**From:** David Margolis-Pineo  
**To:** Helen Donaldson  
**CC:** David Senus; Dianne Gagnon; Marc Spiller; Tom Errico  
**Date:** 6/6/2013 2:38 PM  
**Subject:** Curb Waiver Request - Pomeroy

**Pomeroy Street**

MINOR STREET CONSTRUCTION
POMEROY STREET
 PORTLAND, MAINE

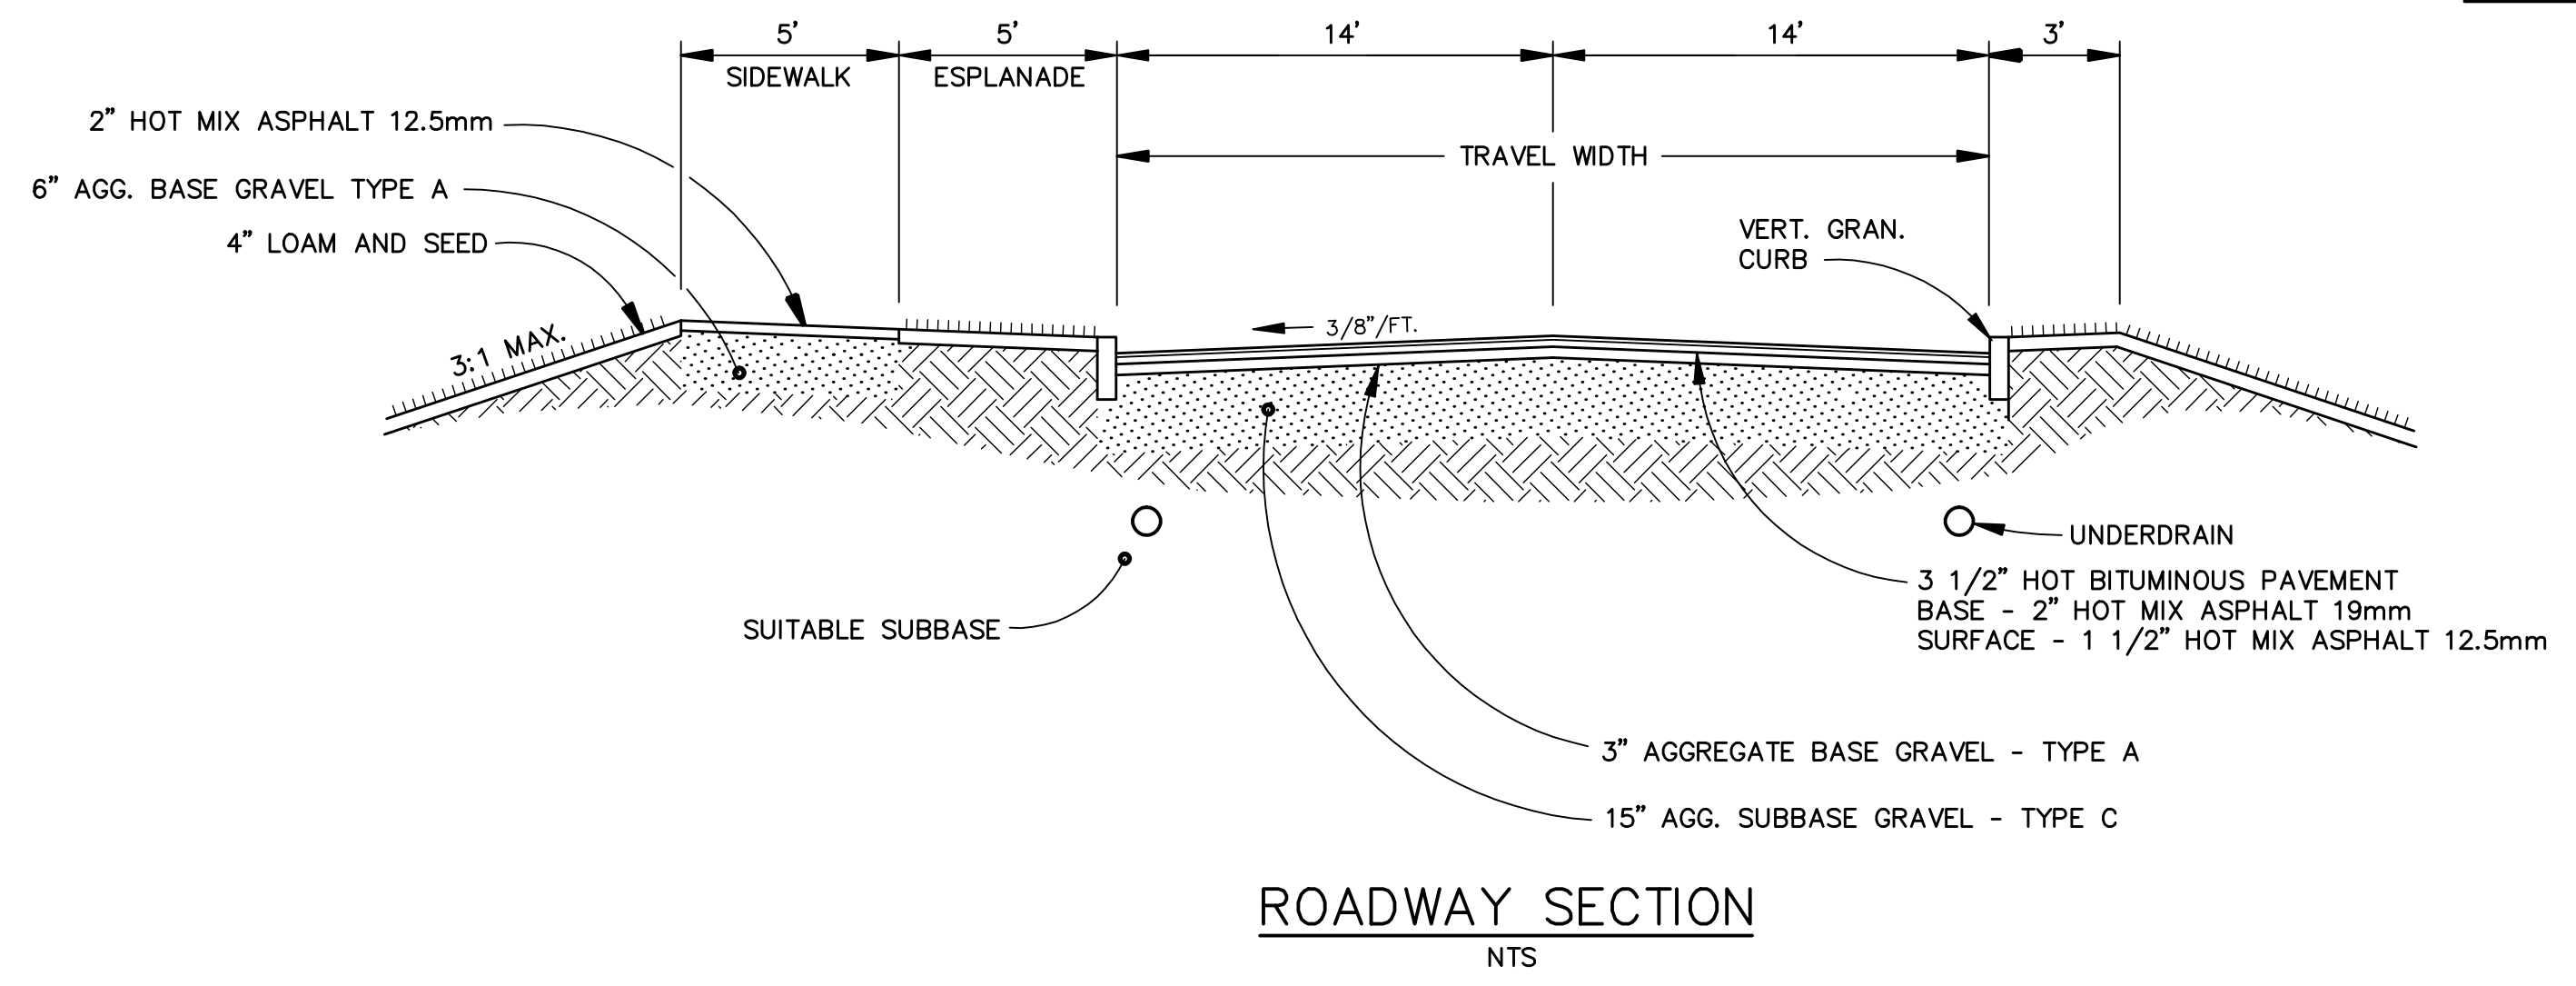
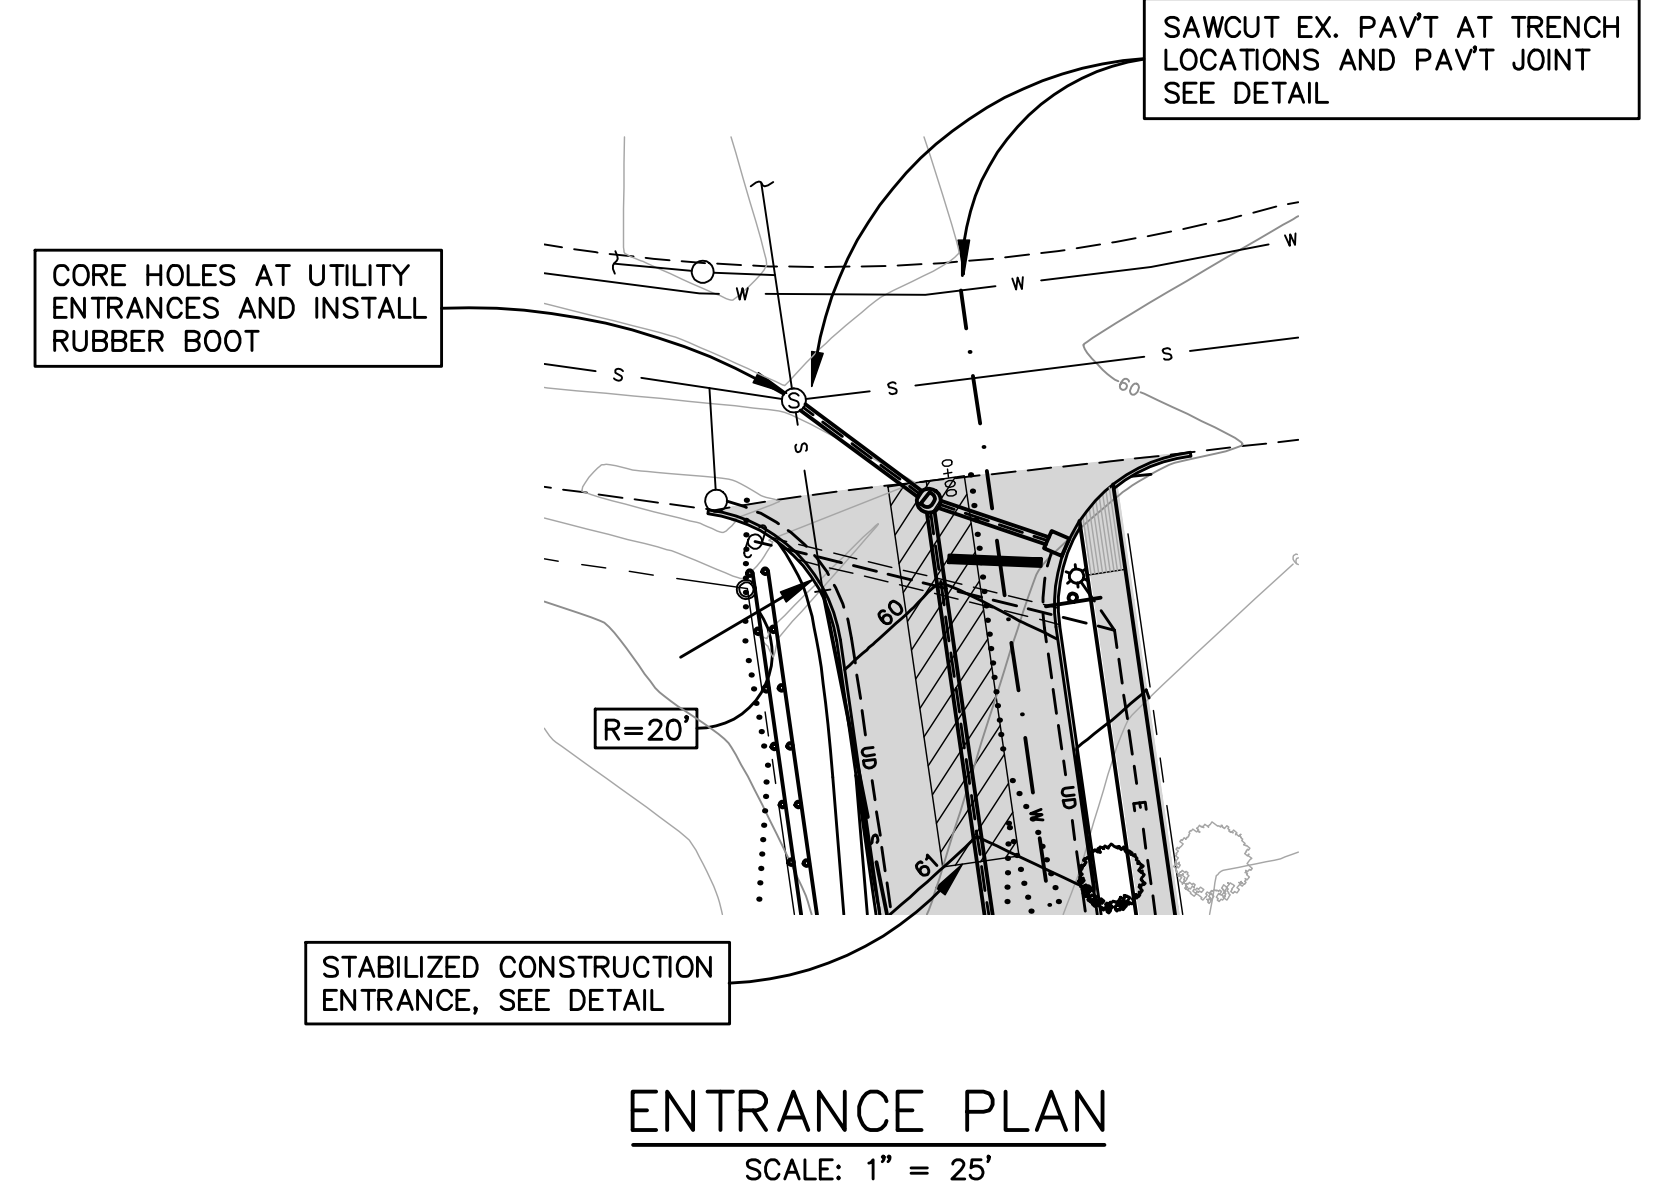
Public Services is agreeable to waiving the curb requirement for the Pomeroy St project. With the elevated street directing all street drainage to a soil filter for treatment, curb would impeded the drainage for this treatment.
